Project No: 315035

Oaklands Farm Solar Park - Glint & Glare Review

South Derbyshire District Council

Figure 4 Assessed road receptors

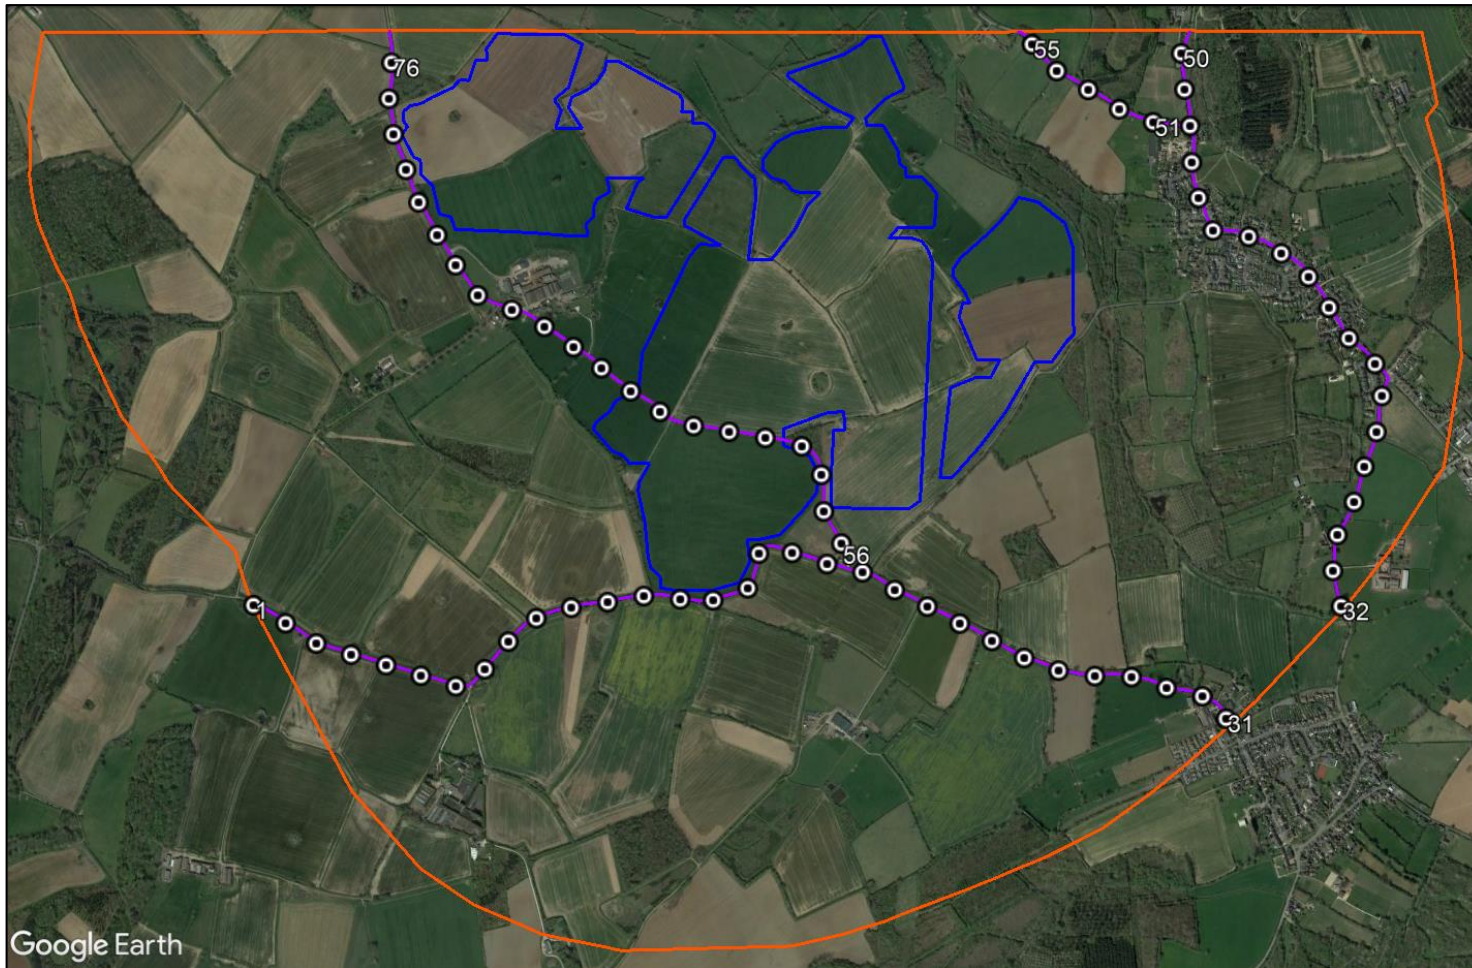
There are only 54 road receptors presented in the roads receptor table in Appendix G. Based on Figure 4 within the report, it is understood that receptors 56 to 76 represent Coton Road.
